North Wales Wind Farms Connection

Deadline 2

Interested Parties Ref: **NWWFC-AFP012 and NWWFC-AFP011**

Our comments on the Applicant's response to our RR No. 90.

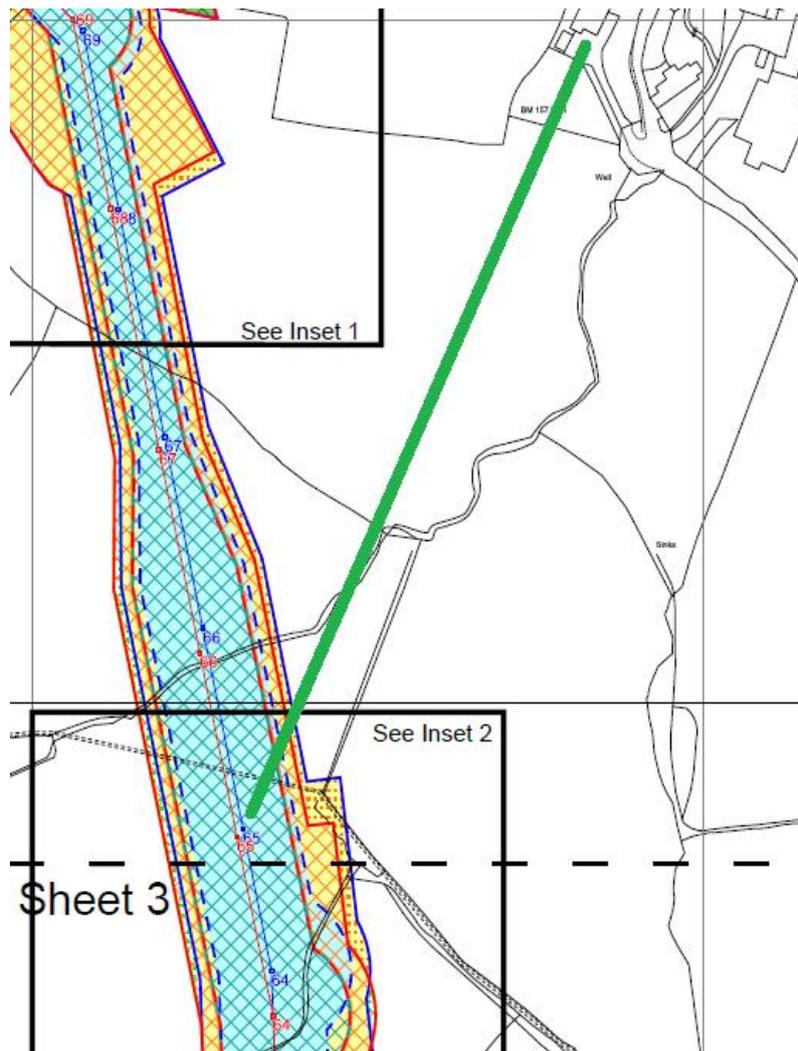
16.11.57. “*The proposed 132kV Overhead Line would briefly skyline as it reached the rising land adjacent to the B4501*” We restate that there are two separate skyline occurrences, one to the south and one to the west as directly viewed from [REDACTED] main room windows. The nearest skylined pylon (pylon 69) being 185m away from viewers at [REDACTED] windows (See Fig1, Fig 2). An existing

The words 'briefly skyline' are not congruent with the likely visual effect. At least four pylons are likely to skyline on the west view alone (pylons 68, 69, 70, 71). Pylon 72 may also be partly visible, but this is uncertain. Approx 200m of the overhead line extends across the west view.
